CITY OF ALBUQUERQUE

August 19, 2024

Re: JLM Living Paseo
Traffic Impact Study (C10D003)
DRAFT July 2024
Via email jkruse@lee-eng.com

The subject Traffic Impact Study (Study) draft received on July 31, 2024, has been reviewed by the City of Albuquerque Planning Development Transportation Section. The City has the following comments to be addressed.

Figure 1: Site Plan

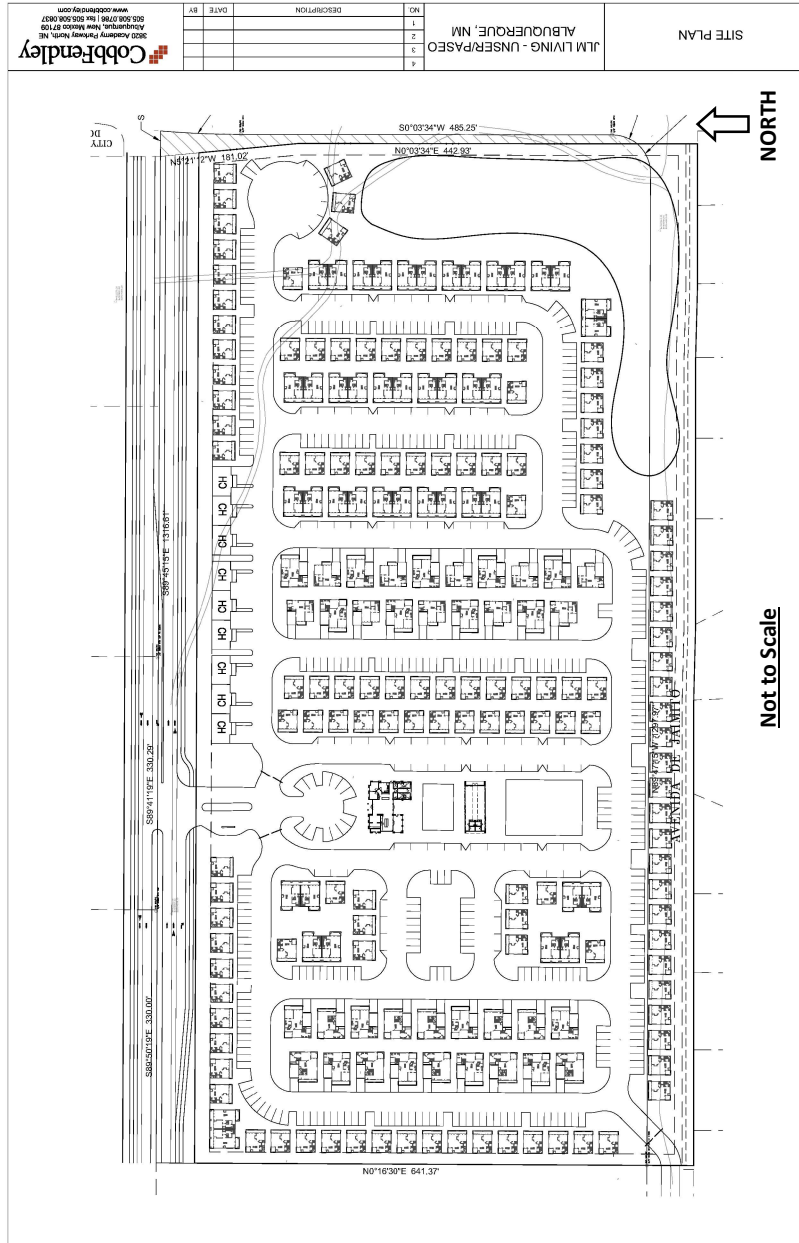
2. Revise the Site Plan to include: (1) Ave De Jaimito from Universe Blvd to the site and (2) Unser Blvd.
3. The Study infers to construct Woodmont Blvd from Universe Blvd to Unser Blvd; however, the ROW does not exist and this site does not abut Universe Blvd, so it is not clear the intersection of Woodmont Ave. and Universe Blvd will be created with this project. If not constructing Woodmont Ave west to Universe Blvd, provide an analysis and recommendations that do not include the intersection of Woodmont Ave and Universe Blvd.

4. Woodmont Blvd is to be a 4 lane roadway from Universe Blvd to Unser Blvd. Please revise the Site Plan and add the construction of Woodmont Blvd, including extents, to the Site Recommendations.
